**Application by National Grid Electricity Transmission Plc for an Order granting
Development Consent for the Richborough Connection Project**

Deadline 3 Submission on behalf of South East Water

Response to Mott MacDonald Report

Project No: B14000AT
 Document Title: Response to Mott MacDonald Report
 Document No.:
 Revision: 0
 Date: 3 August 2016
 Client Name: SEW
 Client No:
 Project Manager: Alastair Smith
 Author: Chris Fisher
 File Name: V:\B14000AT - Broad Oak Reservoir Advice to SEW\9 Reports & Outputs\Deadline 3 documents\Jacobs response to Mott report_3rd Aug_for issue.docx

SECTION B-B
BETWEEN PC8 & PC9

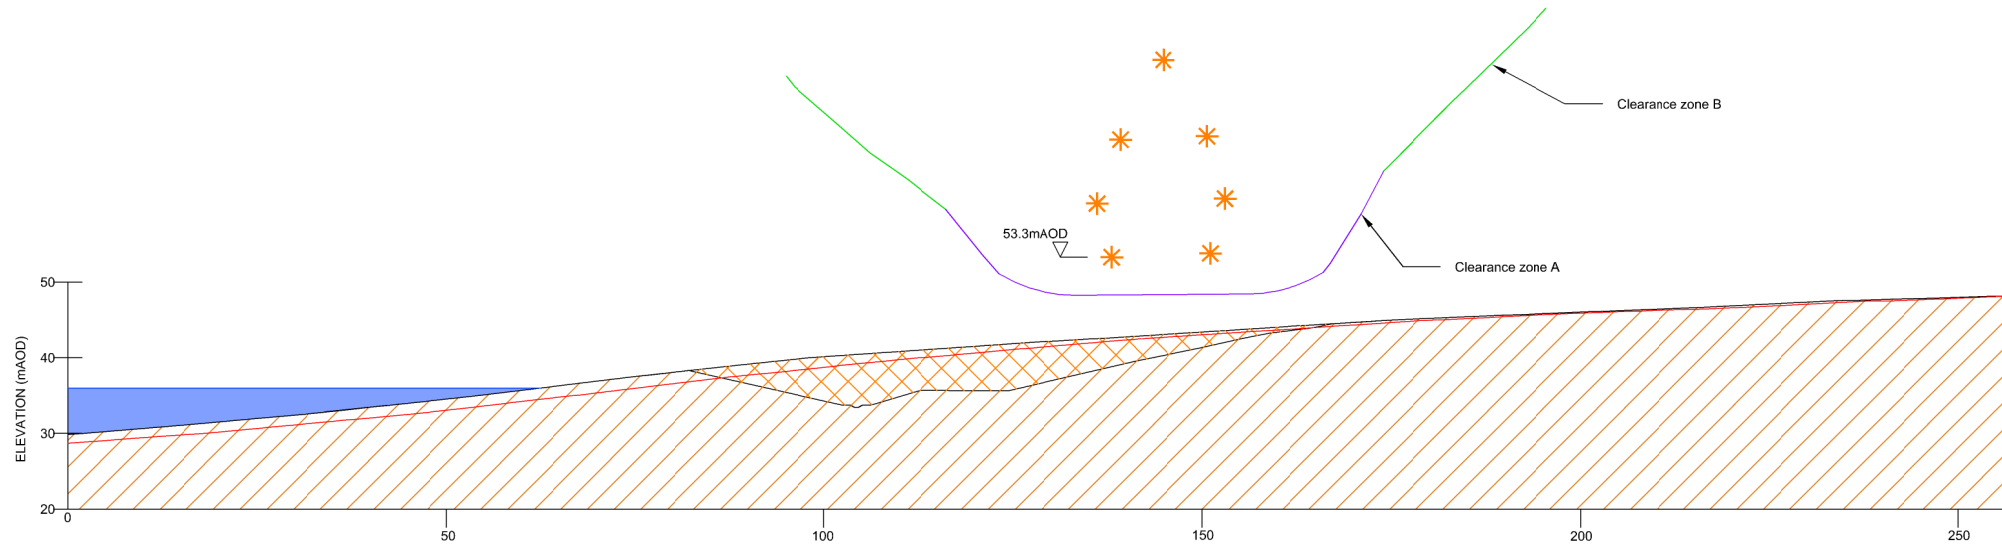
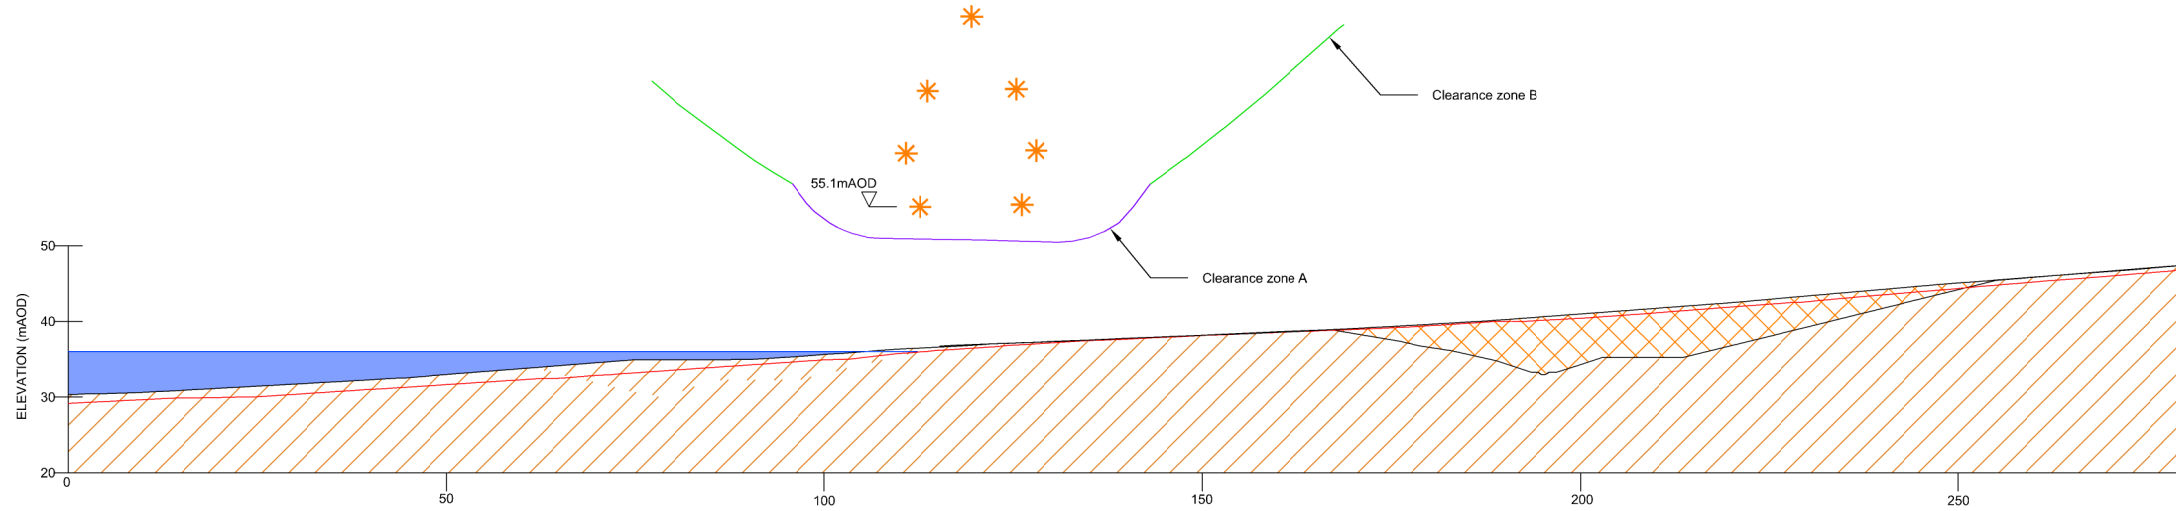
The Mott MacDonald report does not consider the extent of mitigation required which will vary depending on the final reservoir top water level, for pylon PC9 a size midway between 32.5m and 36m AOD requires the largest extent of mitigation to avoid the pylon as pylon would be located in the centre of the river diversion cutting. The comment that National Grid could design a suitable foundation for PC9 is therefore not relevant.

Figure 5.3 in the report shows a retaining wall as a mitigation to pass the river diversion past PC9, this retaining wall as shown is approximately 10m high, which would not be either visually desirable, lead to additional cost to the reservoir scheme and would potentially be hard to construct. A retaining wall of this height would require tie bars behind the wall which would pass under the foundation of the pylon. There are likely to be additional implications for providing the riparian corridor continuity and function with structures for the retaining walls in place.

**SECTION D-D**  
THROUGH PC9

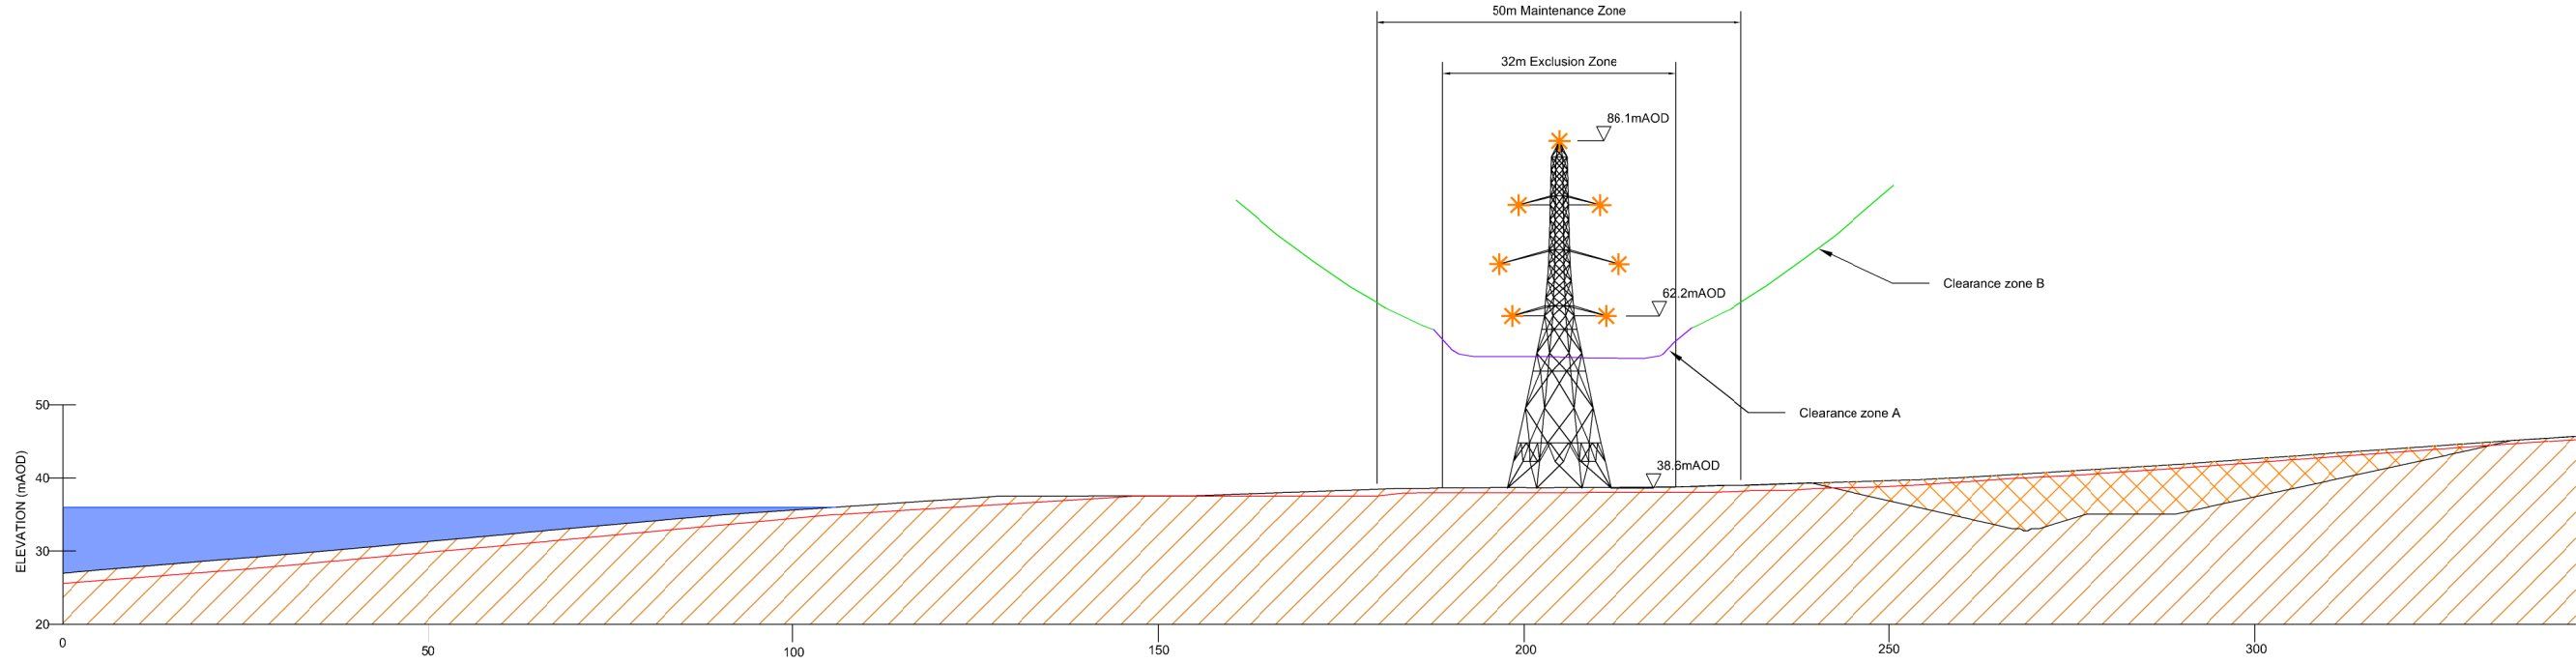
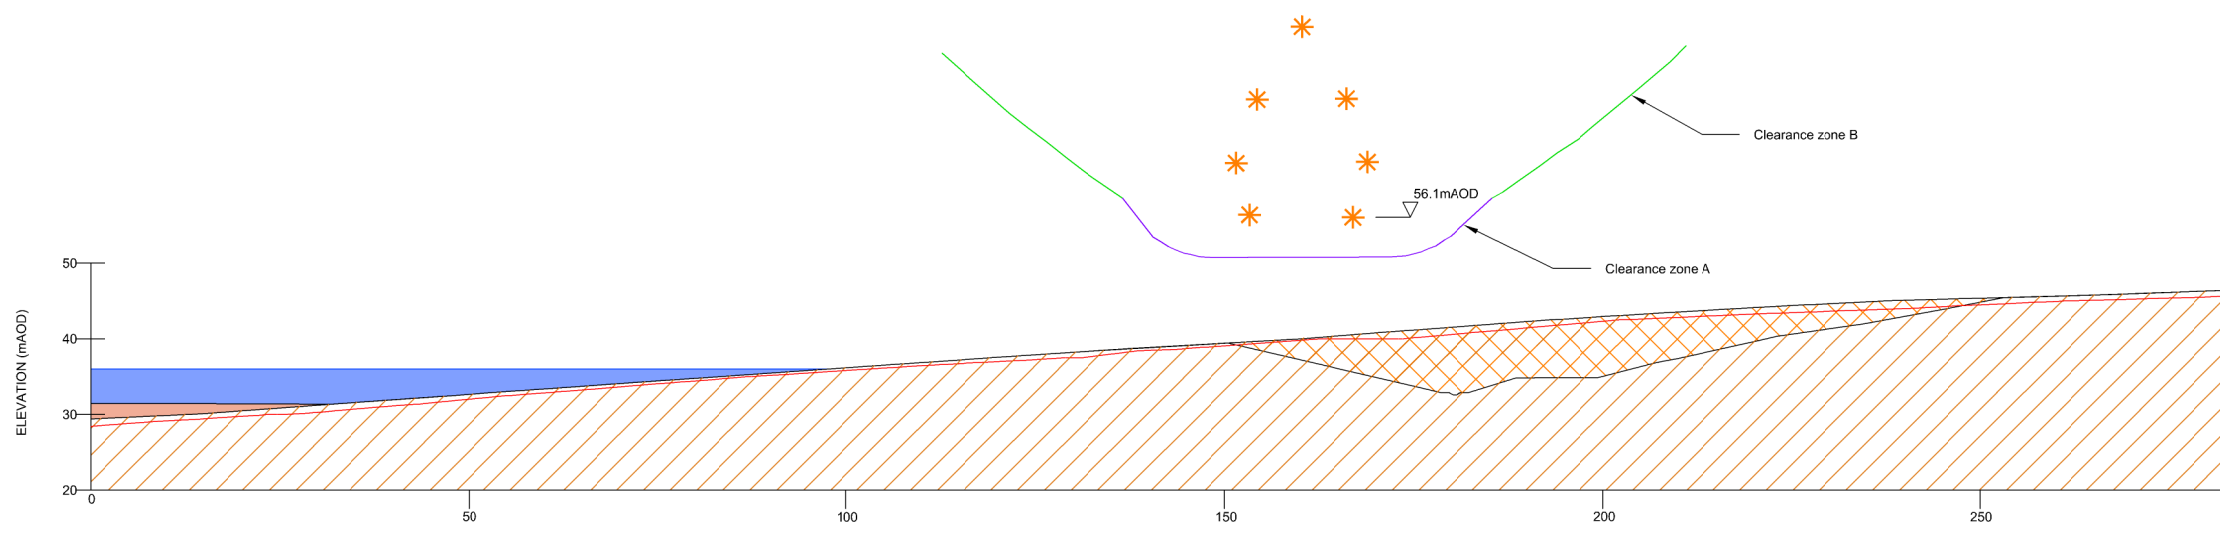
The Jacobs Stage 1b study found that there is a significant interaction between the fish pass and pylon PC10 for the 36m AOD reservoir. Mott MacDonald have presented that: *"a bioengineered fish pass structure may reduce the footprint of the structure. Examples include vertical slot fish pass, Larinier and rock ramp. A bioengineered structure would require acceptance by the Environment Agency, however can be designed for the target species and there is precedent of such structure at UK dams. Additional structures may be required*
